Action Points from Issue Specific Hearing 2: East Riding of Yorkshire Council

Fig 36 - Enhancement measures

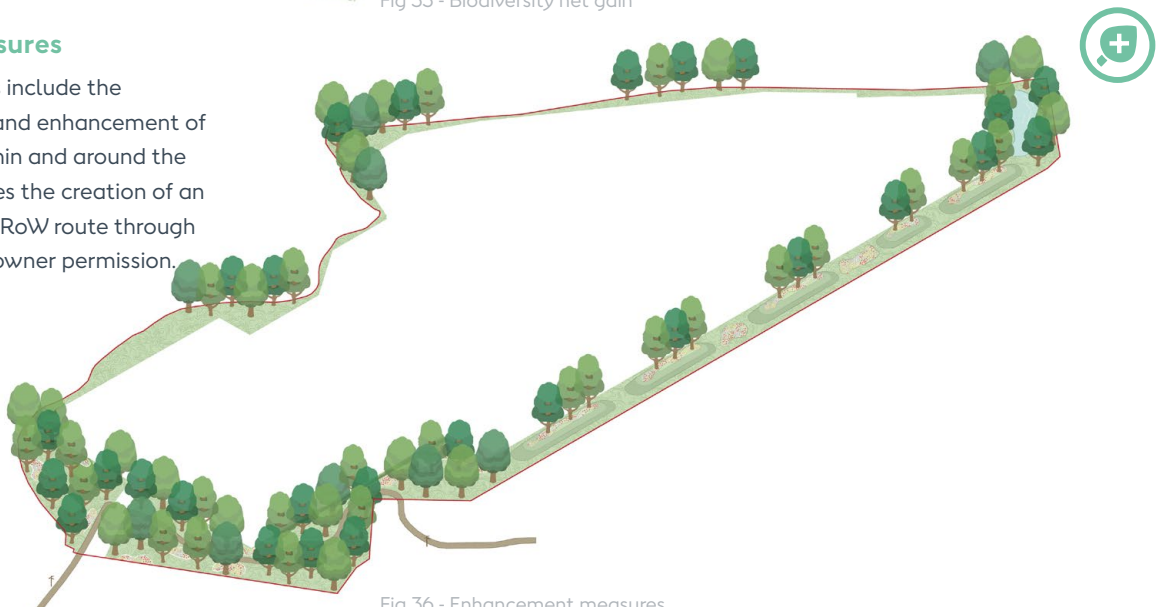
The Local Planning Authority would still prefer to see a stronger landscaped boundary along the northern side of the onshore sub-stations and associated works.
